KITTITAS COUNTY

MEMORANDUM

TO: All Staff
FROM: Public Works Plan Review Team
DATE: October 2, 2024
SUBJECT: SPF-24-00009 4G Farms

4G FARMS SHORT PLAT  
PART OF SECTION 32,  
T. 18 N., R. 19 E., W.M.  
KITTITAS COUNTY, WASHINGTON

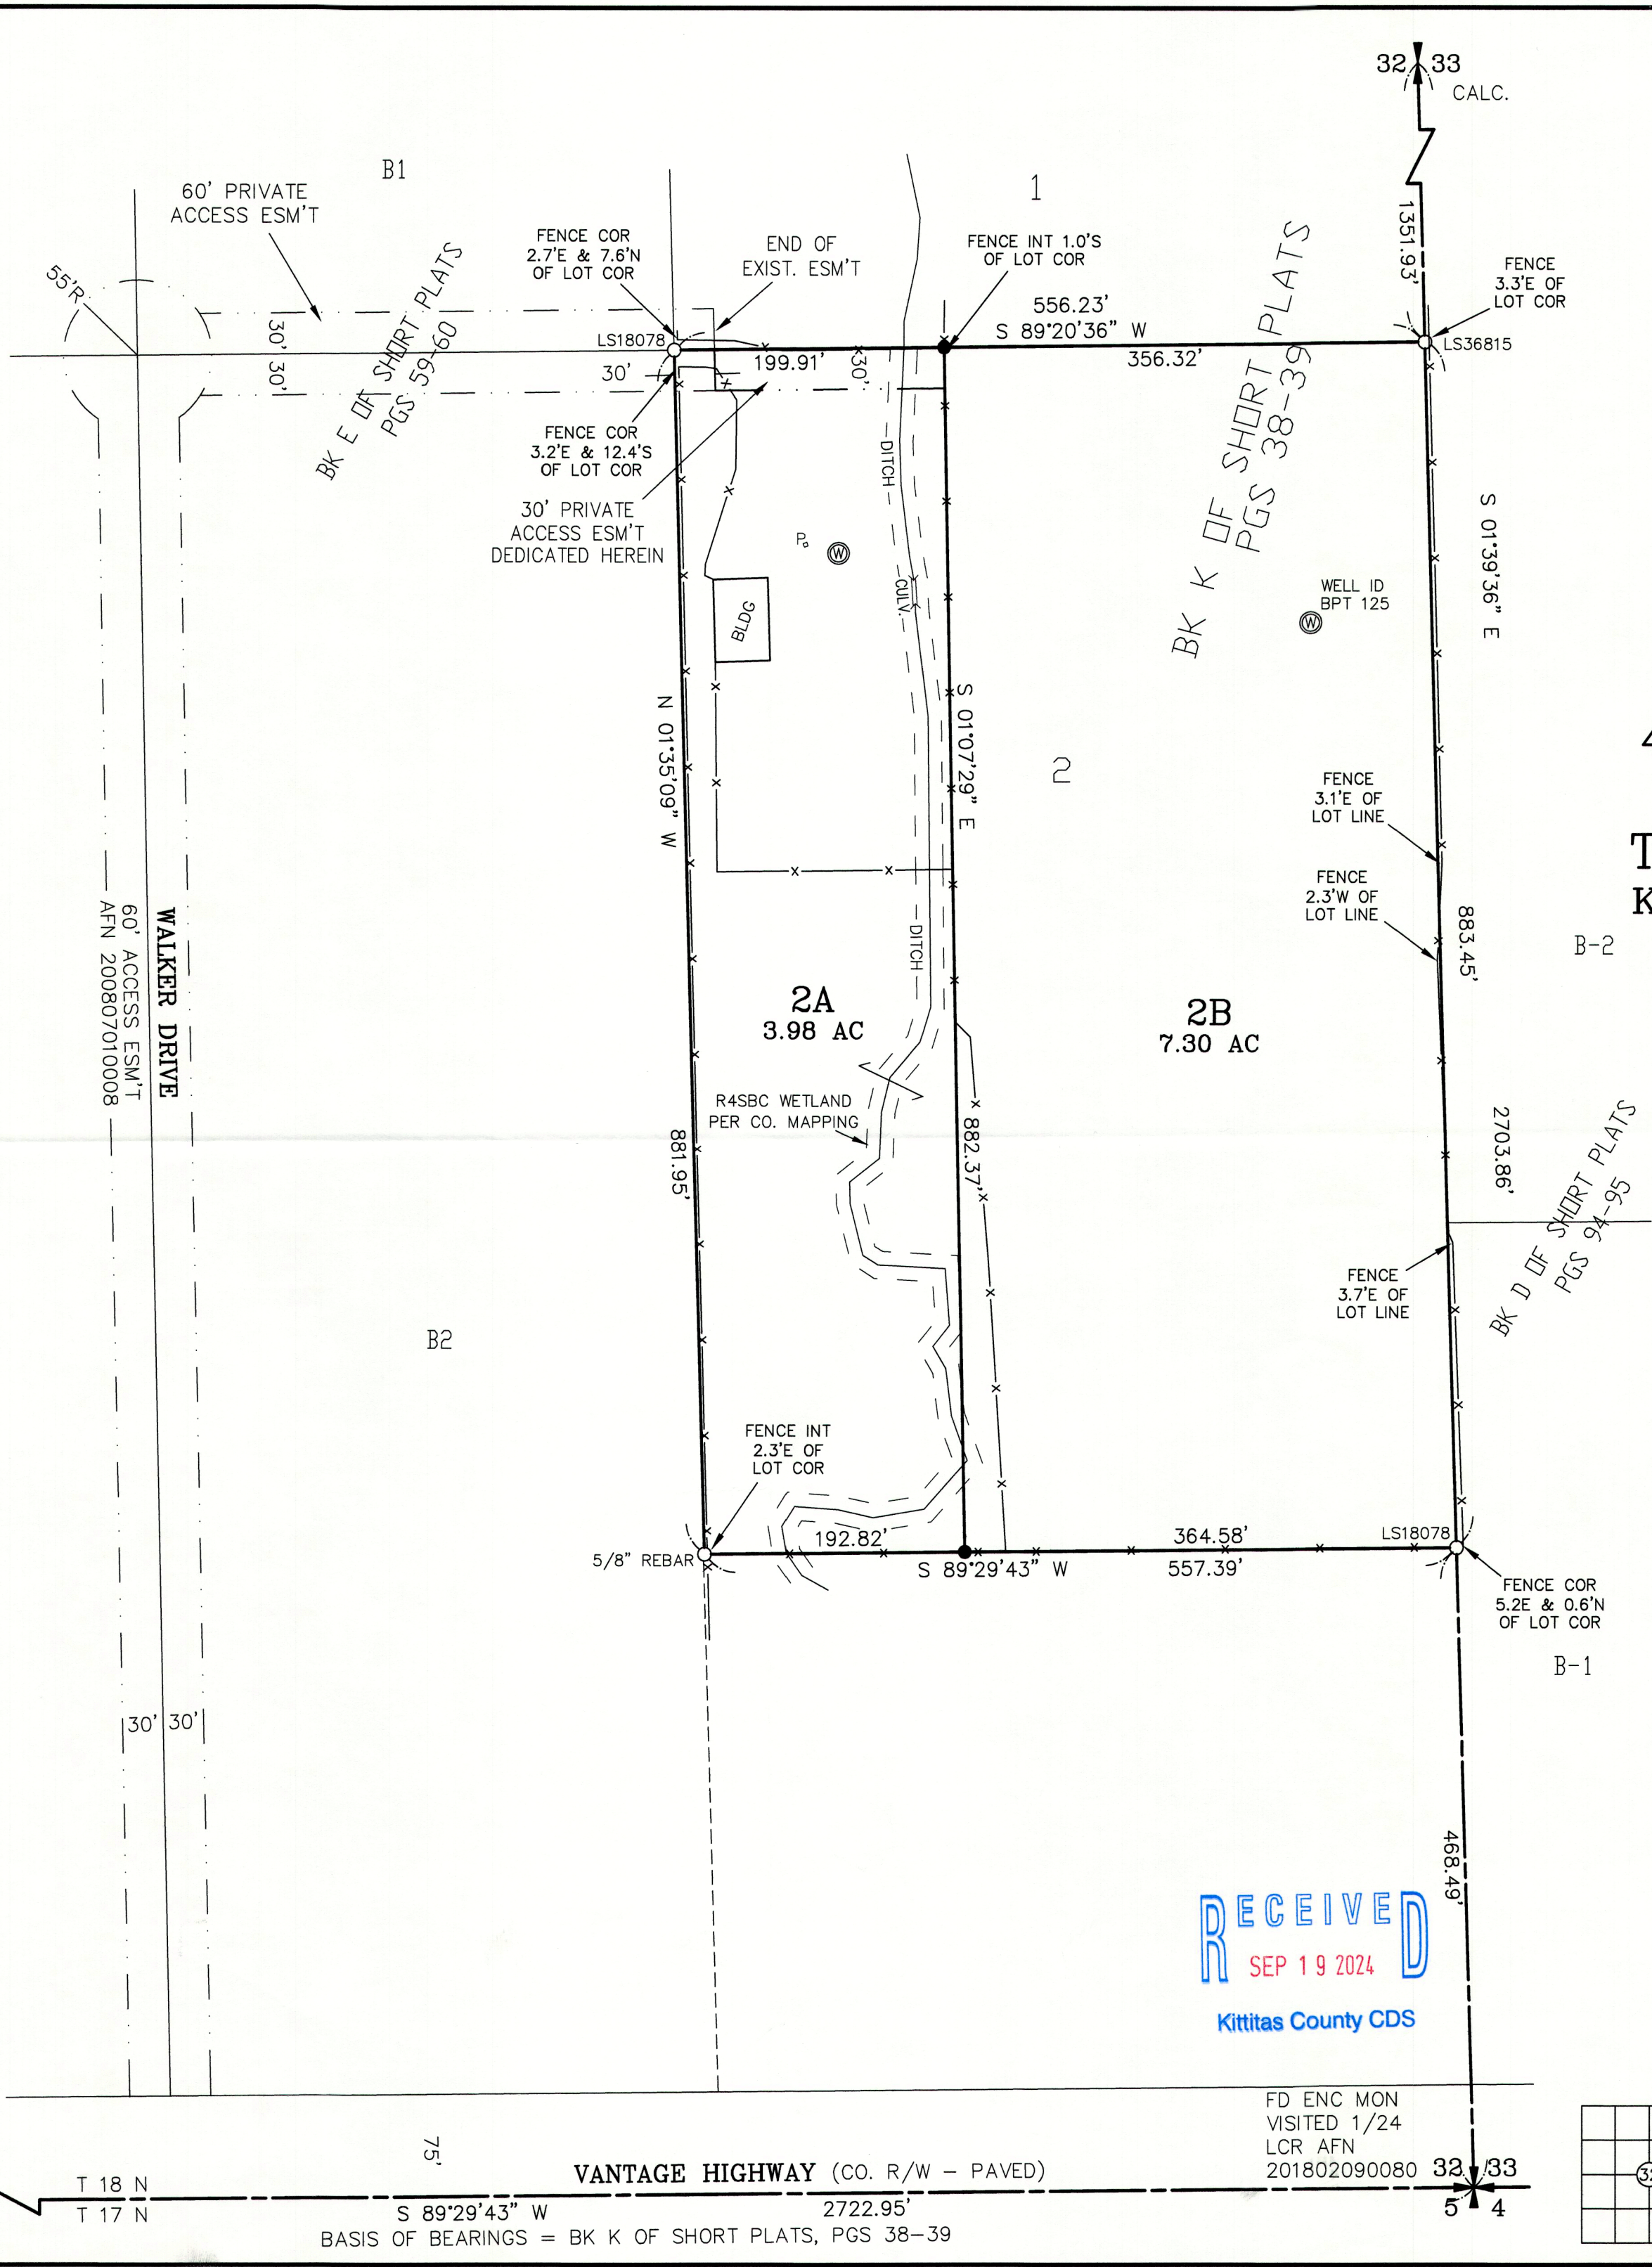
SURVEY	1. The 60' easement shown centered about the North line of adjacent parcel B2 remains uncertain. Please reference if this is an existing easement (including the recording number), or if it is to be created via a separate document. Please note that if it is to be created via a separate document, the signed documents may need to be reviewed by Engineering and / or Access prior to final approval. (JT)
TRANSPORTATION CONCURRENCY	No transportation concurrency requirements for this project. (KAH)
FLOOD	No comments. (SC)
WATER MITIGATION/ METERING	Water mitigation and metering requirements have been met. No additional comments. (SC)
AIRPORT	No comments. (JS)
